CITY OF ALBUQUERQUE

April 10, 2012

Re: Eagle Vista Apartments
Grading and Drainage Plan
Engineer's Stamp dated 3-2-12 (B13/D002C)

GRADING PLAN

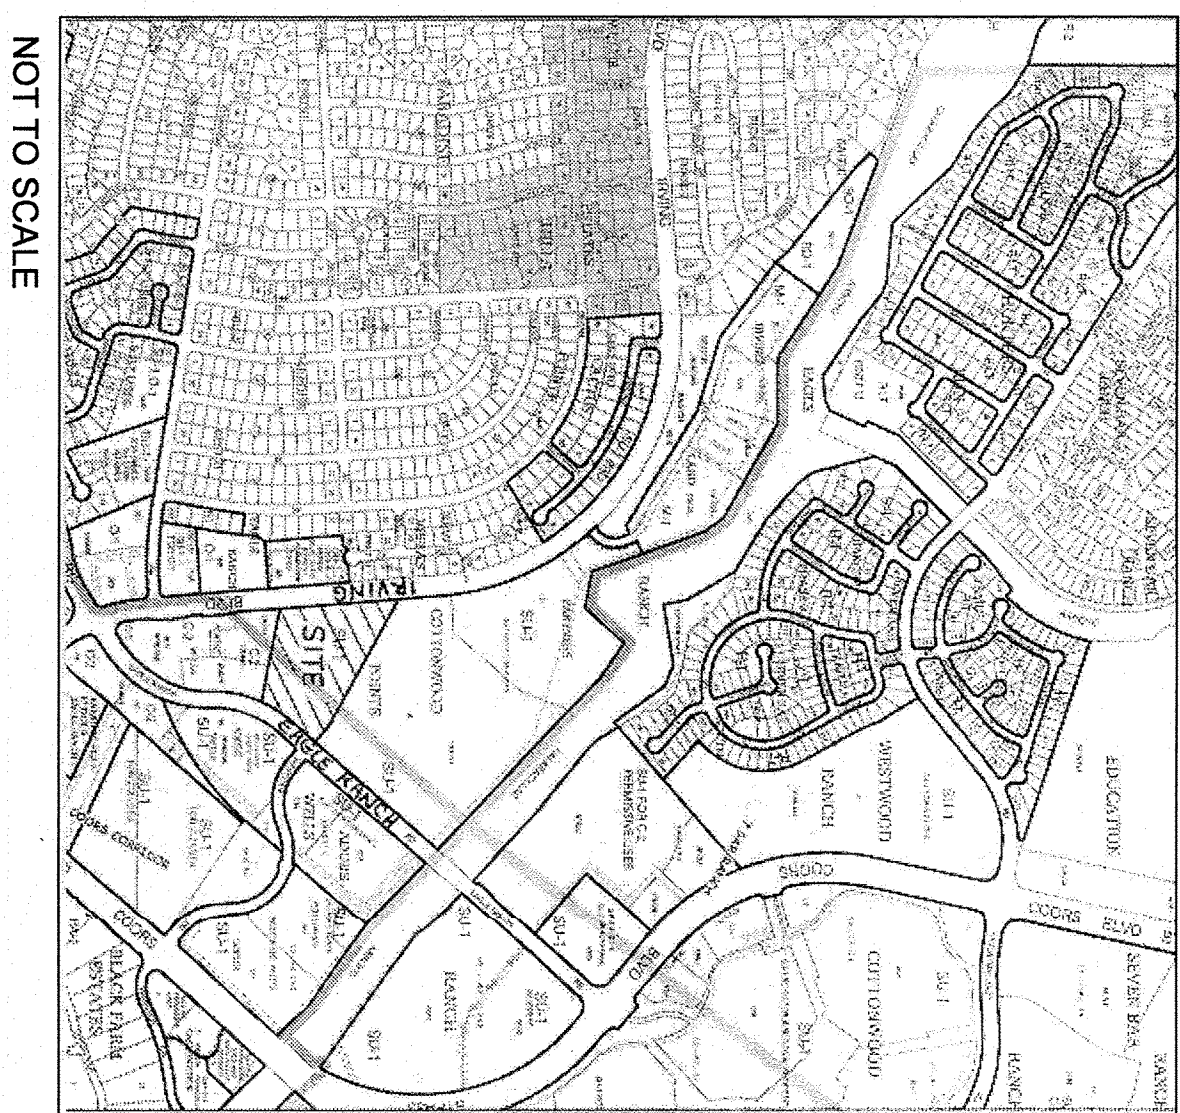
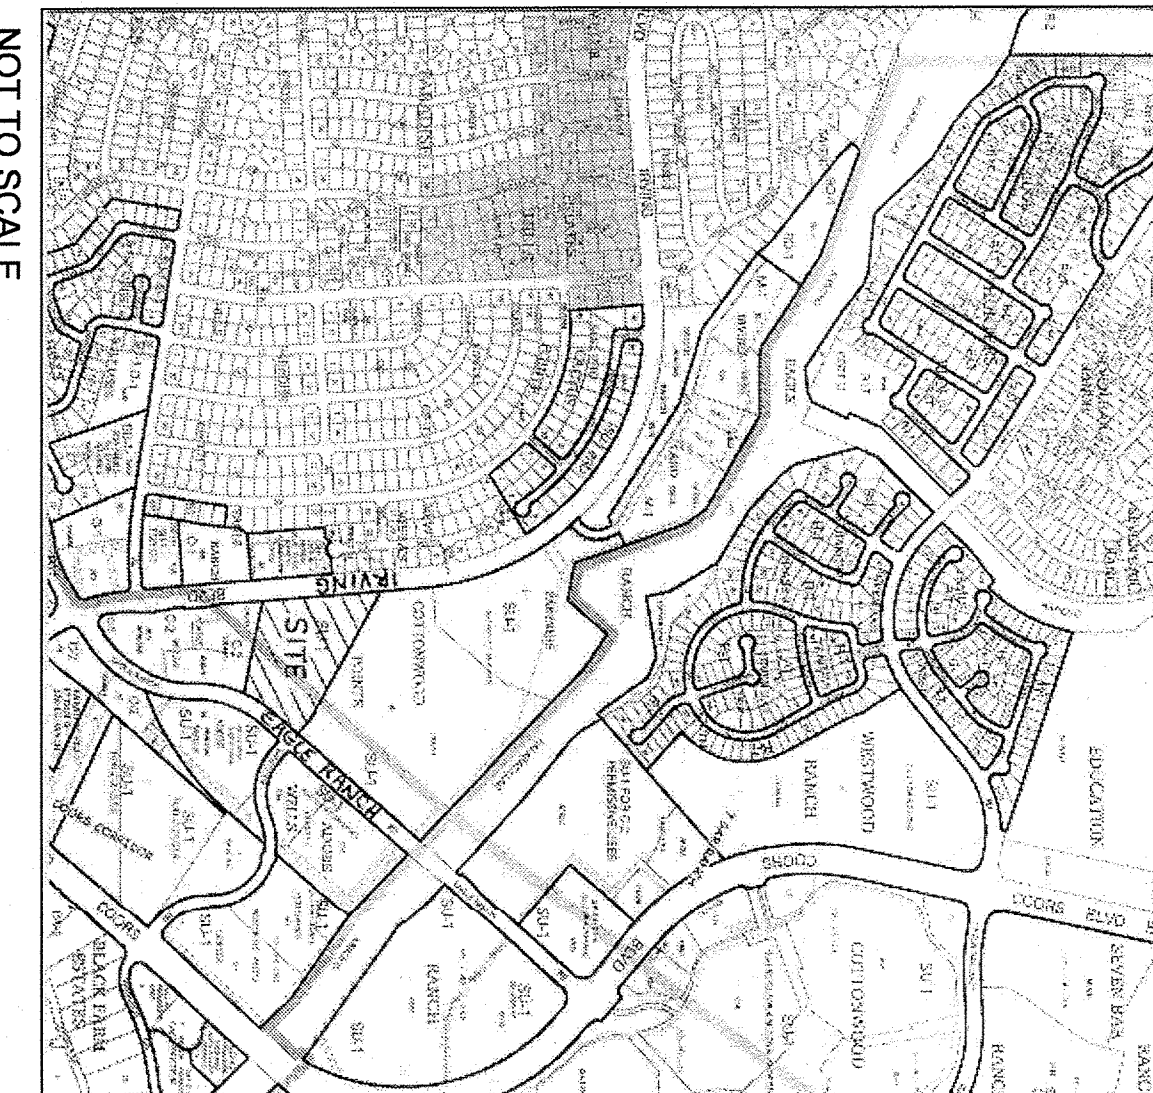
- Provide inverts at the inlets, Manhole and Tees.
- A SO-19 permit is needed for the sidewalk culvert. Specify the COA Standard 2236 with welded bolts for the sidewalk culvert. An engineered means of erosion control is required when the slope is greater than 3:1. Is a swale being placed behind the wall to direct the flows toward the sidewalk culvert? What is the width of the sidewalk culvert? Provide direction of roof flows for this area.
- Depress landscape areas for water harvesting.
